Consultation Response from: KC Environmental Health (Pollution & Noise Control)

2025/90090 - East Bierley Community Sports Association, Hunsworth Lane, East Bierley, BD4 6PU

Variation of conditions 2 (plans and specifications), 14 (remediation) and 22 (ground conditions) and deletion of condition 13 (remediation) of previous permission 2021/90357 for works to existing sports facilities – amendments to layout, removal of pre-commencement trigger from condition 22, and removal/variation of remediation requirements.

Date Responded:
7th March 2025

Title: **Proposed Site Plan**
Client: **East Bierley Community Sports Association**

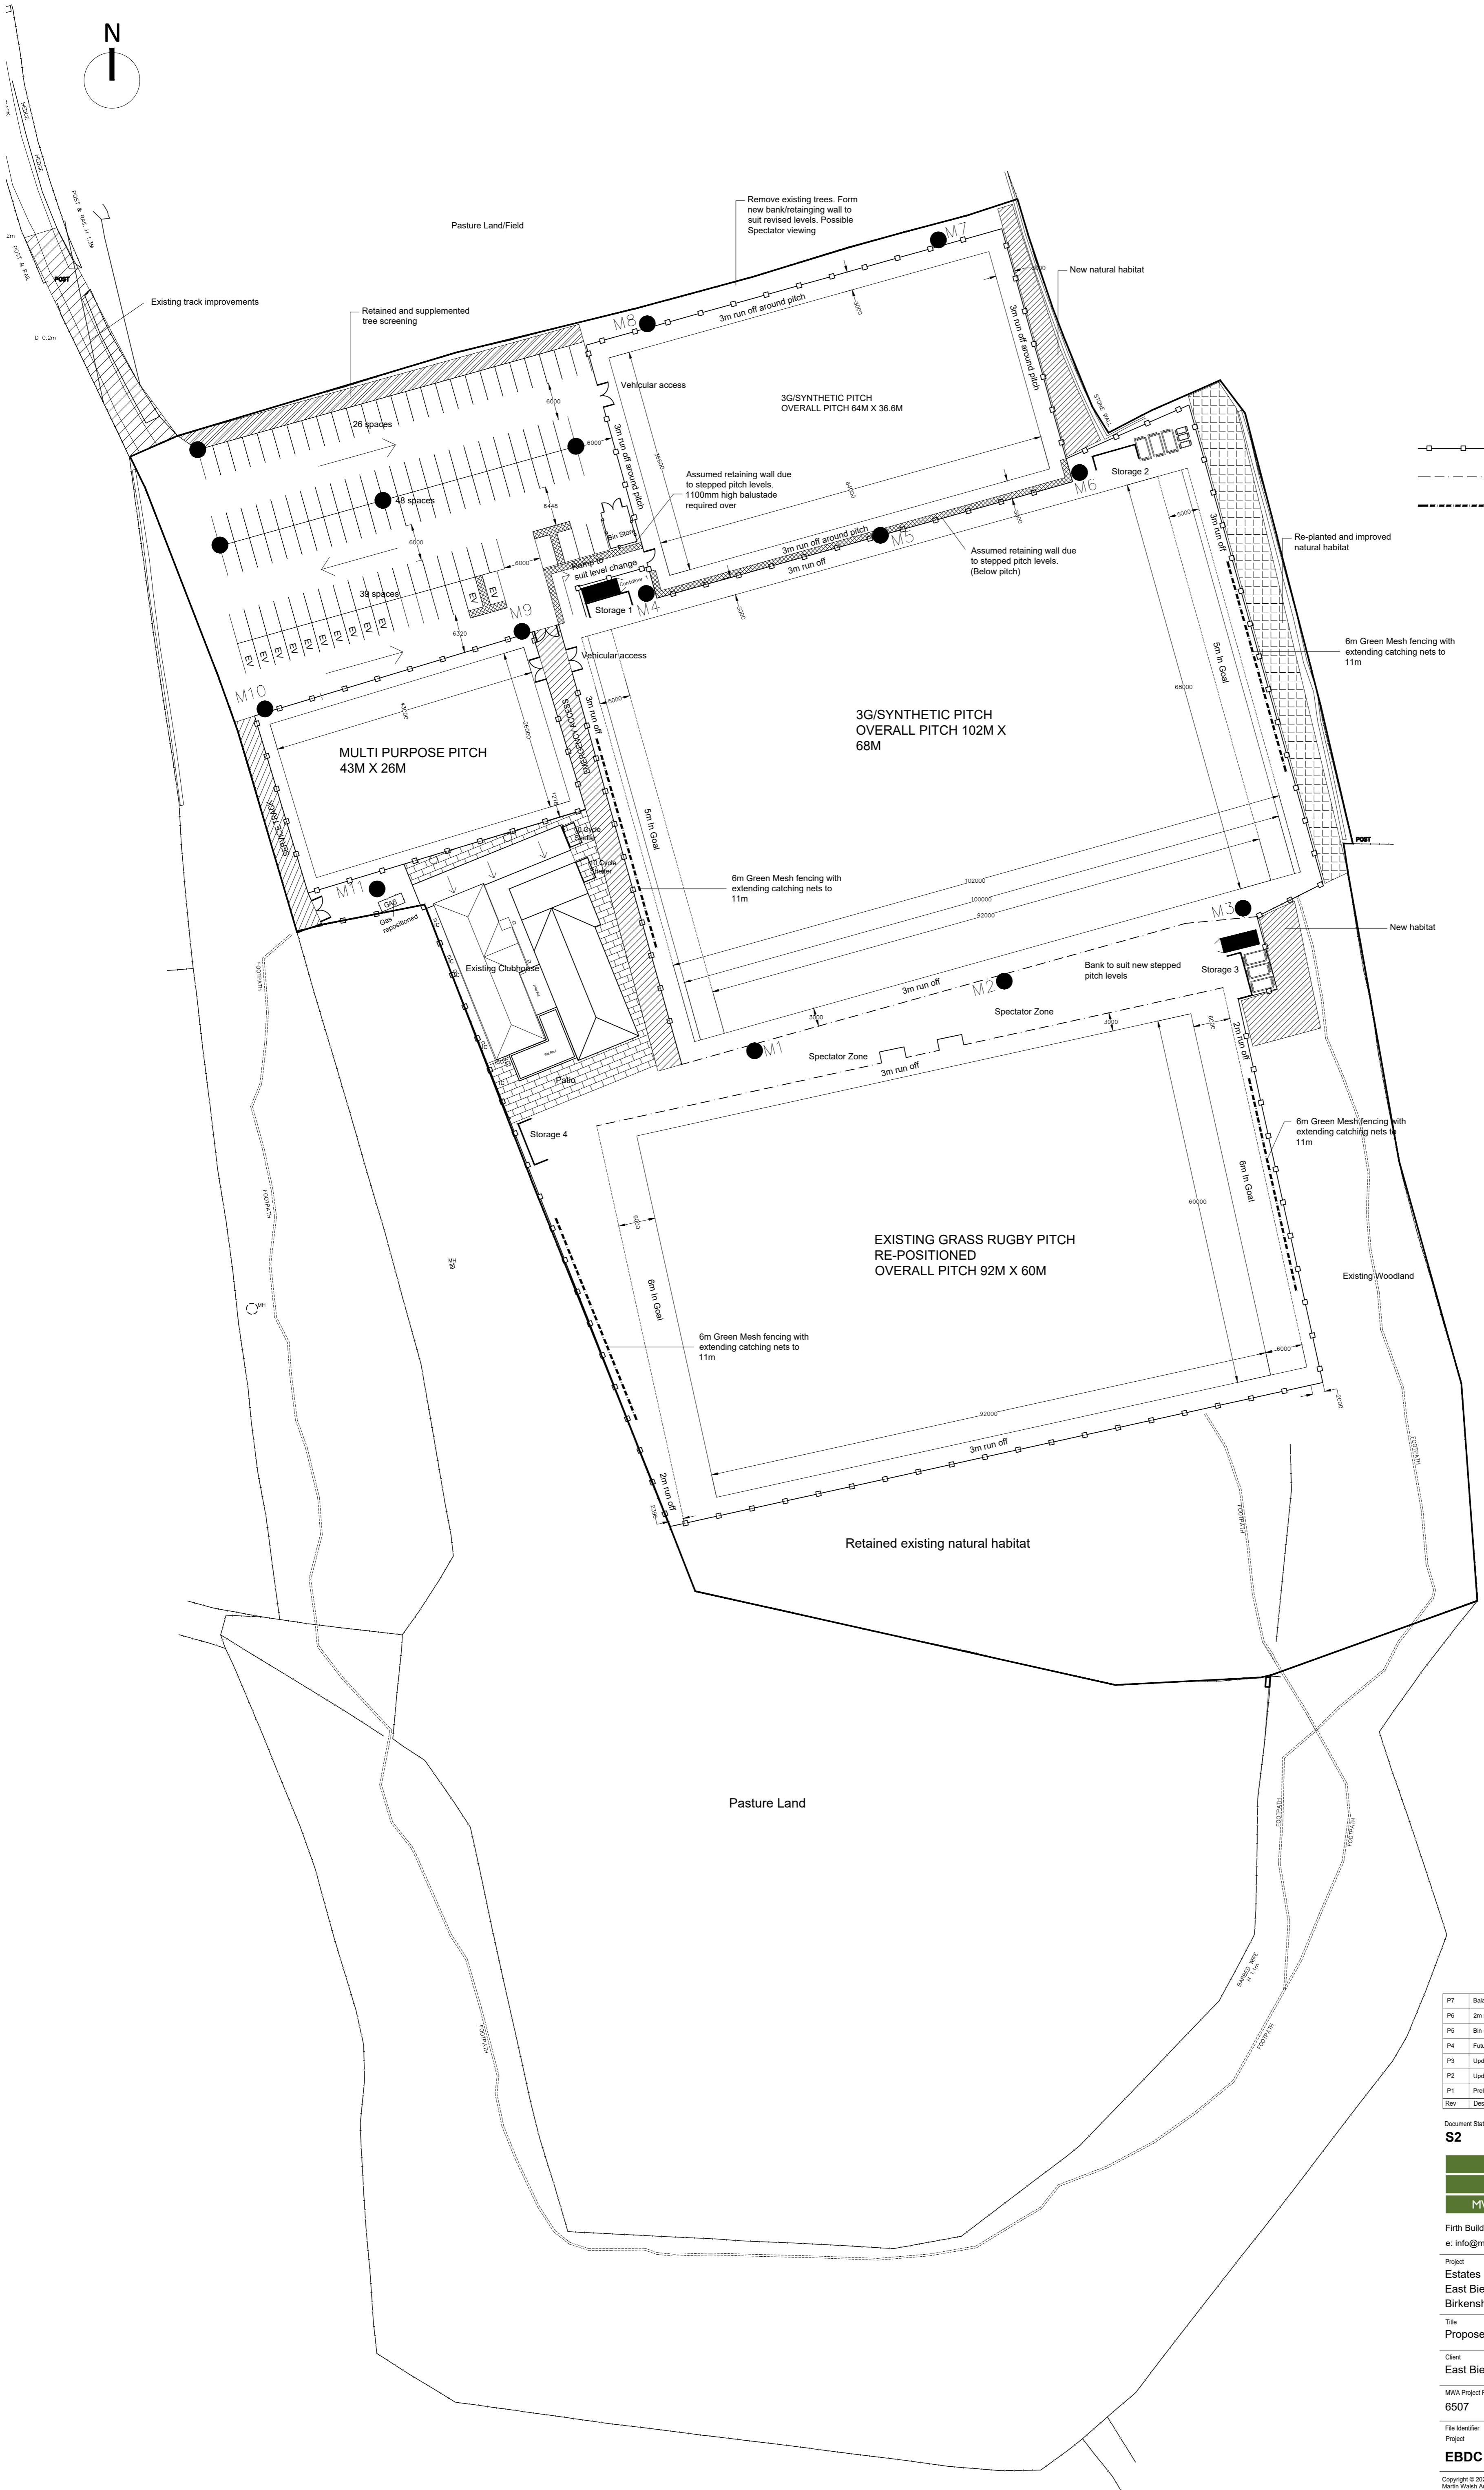
We note the applicant seeks to vary Condition 2, and acknowledge the changes in pitch size. Environmental Health have no objections to the variation of condition 2.

No objection to the variation of Condition 2.
